**Subject:** Rezoning Petition Review

**Date of Review:** January 25, 2022

**Rezoning Petition #:** 21-206

**Location of Property:** Approximately 4.20 acres located on the west side of N Tryon St, east of I-85 and south of W Mallard Creek Church Rd.

REZONING PETITION 2021-206  
RZ-2 : TECHNICAL DATA SHEET

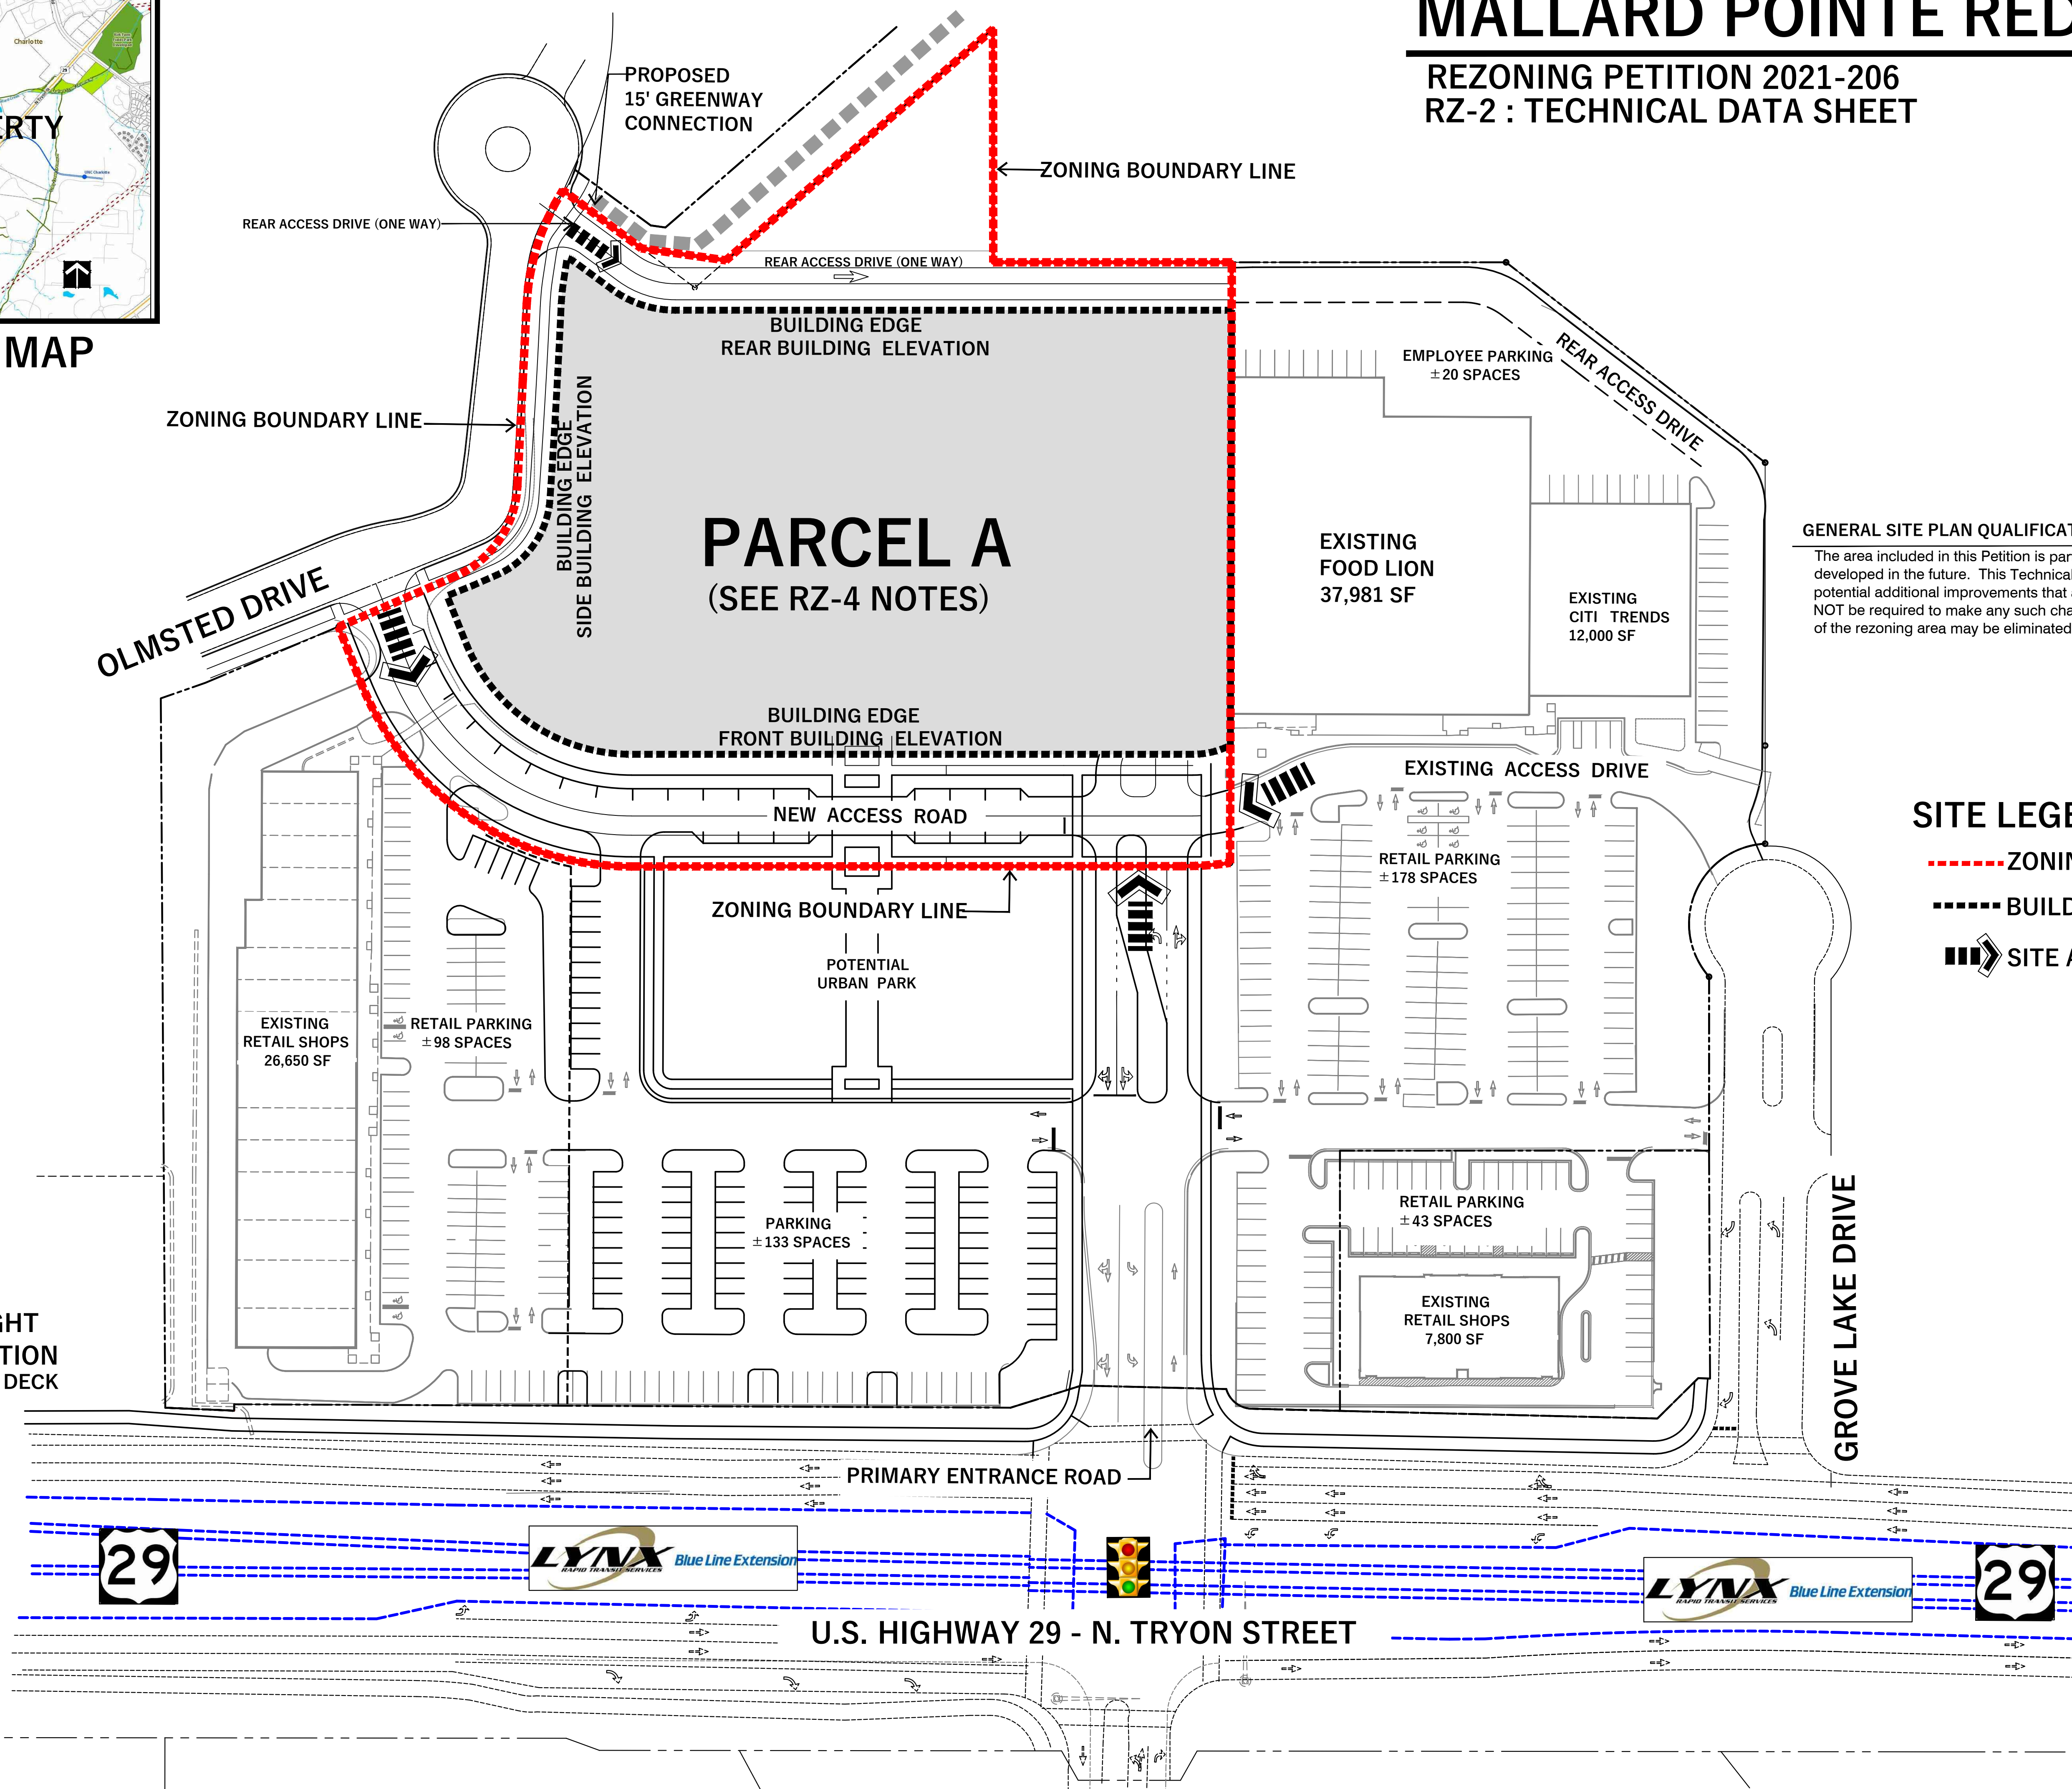
Please remove note 5a in its entirety as this is not determined or approved during the rezoning process.
